Application number: 2025/92713	
What is the application for?:	Reserved matters application pursuant to outline permission 2023/92079 for erect
Address of the site or building:	Rear of, 23 to 43, Moor Lane, Gomersal, Cleckheaton, BD19 4LF
Postcode:	LS10 1NB

Type of comment: An objection	
Do you wish your comments to be published on the website anonymously?	Yes
<p>Re Consultation Response from KC, Lead Local Flood Authority on planning Ref 2025/92737</p> <p>On the 31st October 2025 ( id1111965, 3/11/25) Yorkshire Water wrote to Kirklees Council Head of planning and stated:-</p> <p>“Yorkshire Water object to the discharge of drainage conditions 16, 17, 18, 19 and 20.” These related to the following -</p> <p>No. 16 (Foul &amp; Surface Water Drainage) No. 17 (Exceedance Flood Routing) No. 18 (Temporary Drainage) No. 19 (Foul Drainage) – is this a YW requirement? The LLFA generally do not review foul drainage other to ensure a separate system from the surface water drainage is provided. No. 20 (Surface Water Drainage) – completion of surface water drainage.</p> <p>Despite Yorkshire Waters objection to the discharge of these reserved drainage conditions, on 5th November 2025 Kirklees Cou

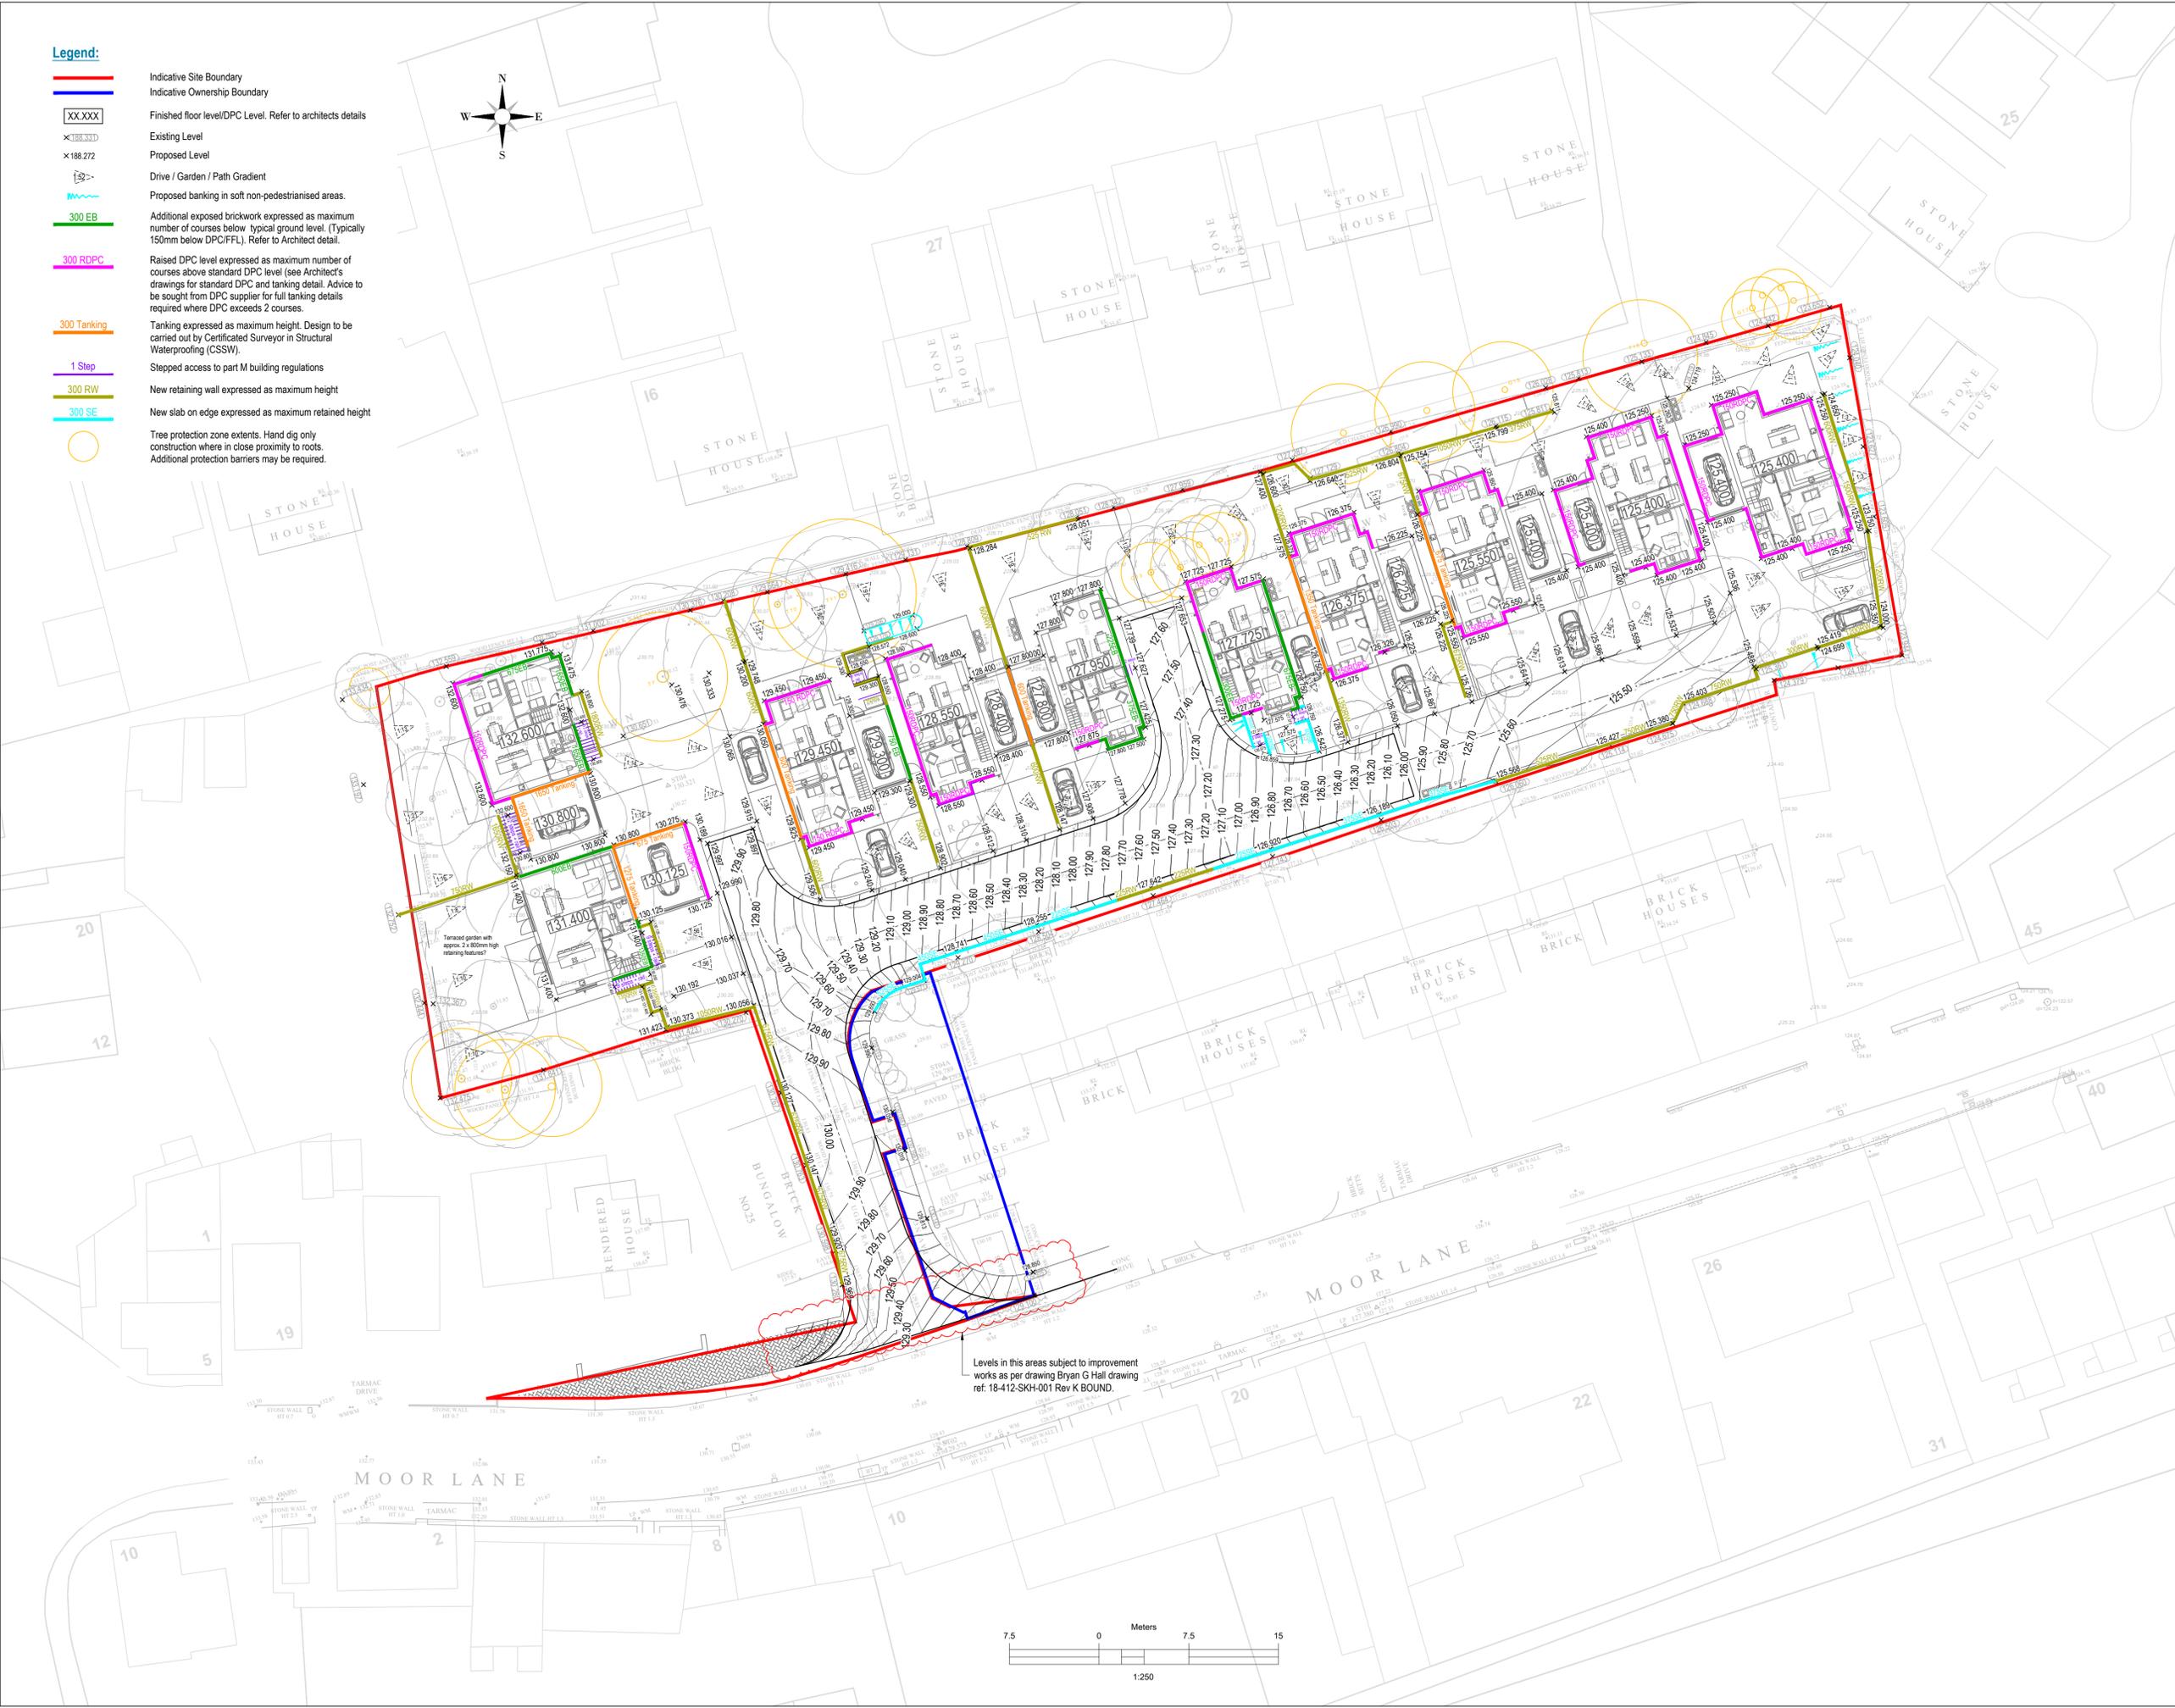
The original plan showed the the flood exceedance route heading towards soft landscaping at rear garden of 19 Summerdale despite the notation referring to it as being 19 Moor Lane.

The latest drawing now shows it heading directly into the private garden of 21 Summerdale.

This garden is enclosed by the house wall and conservatory at the North East corner and a stone wall 2.00 metre high connected to 19 Summerdale which in turn is connected by a stone wall to 17 Summerdale.

The only route for any floodwater to run would be past the end of the Conservatory of 21 Summerdale or through the 900mm wide gate opening in the wall between 19 and 21 or into the garden of 17 Summerdale.

As a result of this proposed route, flooding could potentially affect 14 or so houses in Summerdale and Moor Lane.
